**Inland Rail – Narromine to Narrabri (SSI 9487)
EPA advice on Preferred Infrastructure Report (PIR) and Amendment Report**

I am writing to you in reply to your invitation to the NSW Environment Protection Authority (EPA) to provide comment on the Preferred Infrastructure Report (PIR) and Amendment Report for the above project, as well as the Response to Submissions (RtS).

Figure A8.5 Proposed location of out-of-hours works (map 1)

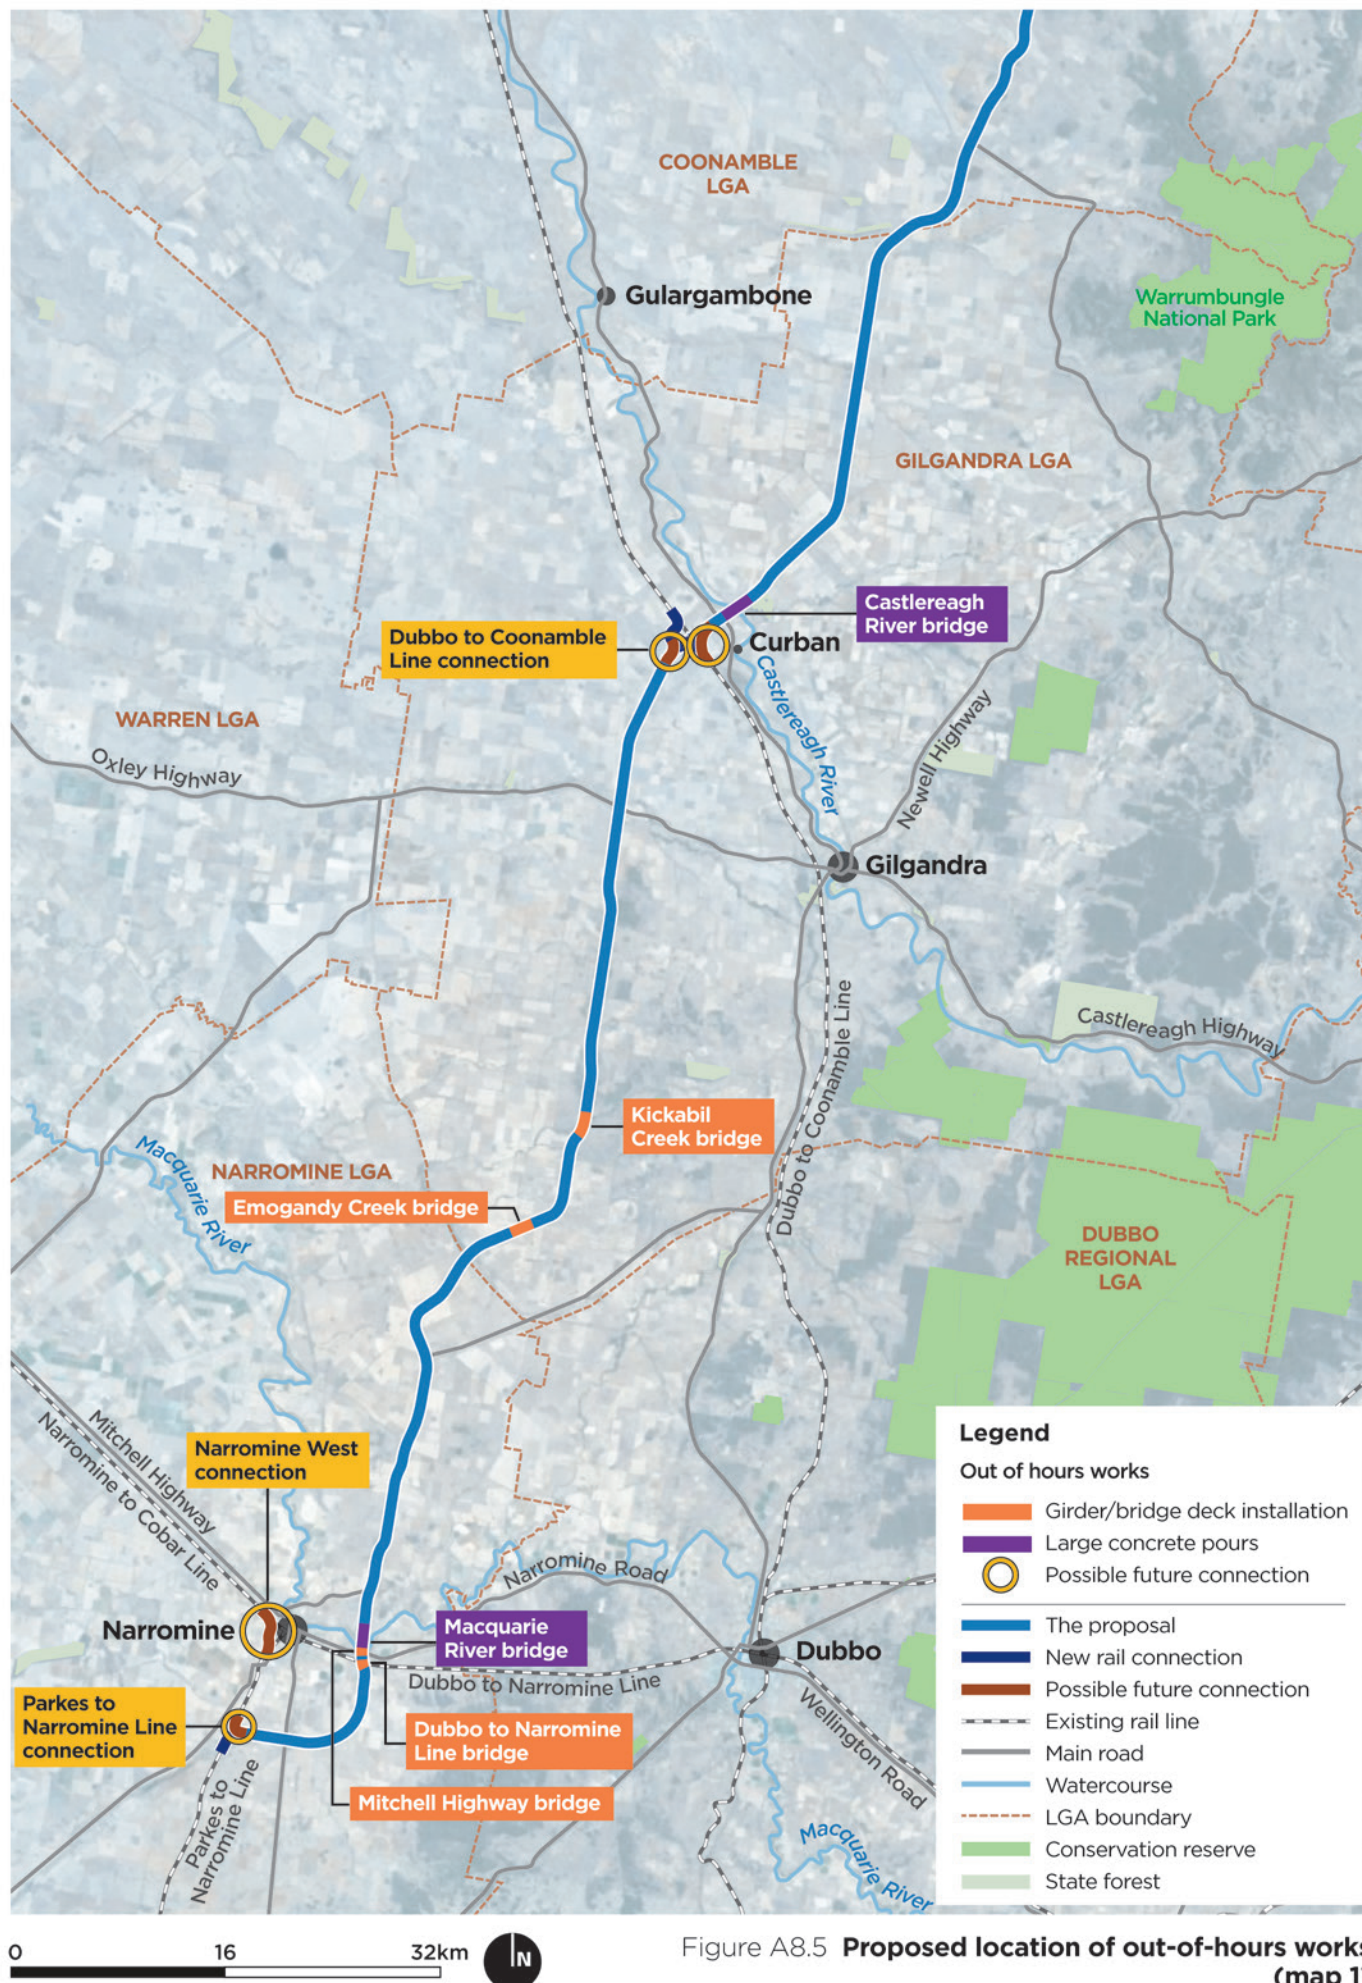
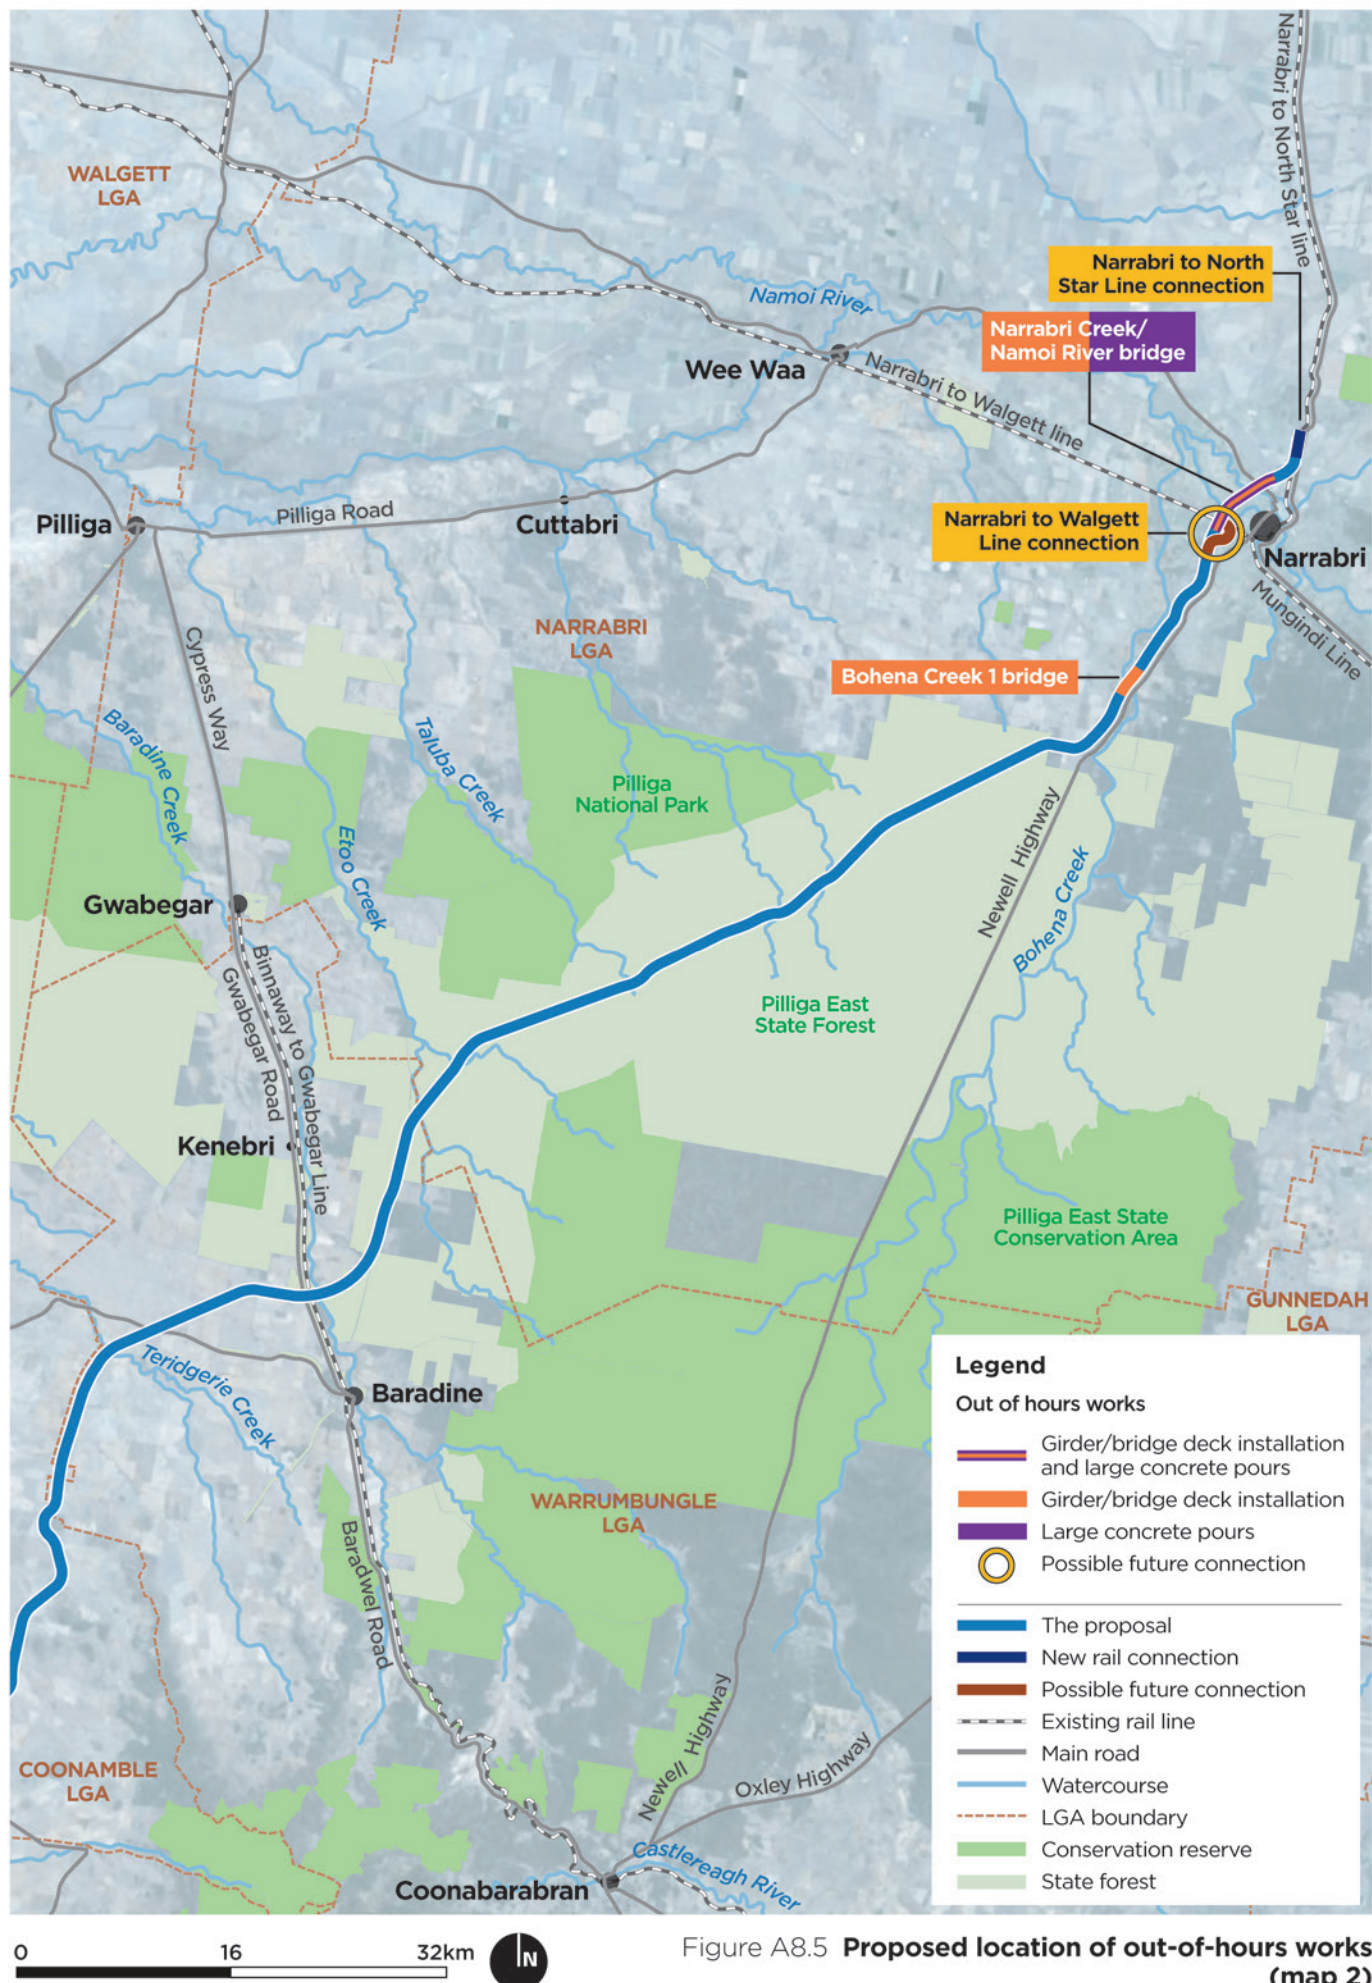
Mitigation for out of hours works in Table 10.1 and 10.2 in the N&V Construction report are not outside of the standard hours in the *Interim Construction Noise Guideline* (DECC, 2009) (ICNG), but rather are outside of proposal hours – that is 6 am to 6 pm. This is also inconsistent with the approach taken for other sections of Inland Rail, such as the recent Albury to Illabo. Out of hours mitigation (and the out-of-hours work protocol) should be based on ICNG outside standard hours. **To provide clarity for sensitive receivers potentially impacted by the proposal, the EPA recommends the PIR be amended to illustrate the mitigation outside standard hours from the ICNG.**

During the meeting of 15 September, ARTC indicated that the 'rail earthworks green zone' appears to identify areas where predicted noise levels fall at, or are below, the night time Noise Management Levels (NMLs) in the ICNG and that works may be undertaken 24 hours a day, 7 days a week. It is not the intent of the ICNG that works outside of standard hours can be undertaken as long as the levels do not exceed the NMLs.

While the EPA acknowledges that noise levels below the NMLs are unlikely to result in significant impacts, noise levels below the NMLs may still be audible at sensitive receivers, particularly in rural areas. **The proponent still has an obligation to justify the need for outside standard hours works for reasons other than convenience in accordance with Section 2.3 of the ICNG and to implement all feasible and reasonable mitigation, management measures, and work practices to minimise noise in accordance with Section 6 and Figure 1 of the ICNG.**

The proponent should also be required to provide evidence of support from the surrounding community to carry out works outside standard hours, as per Section 2.3 of the ICNG.
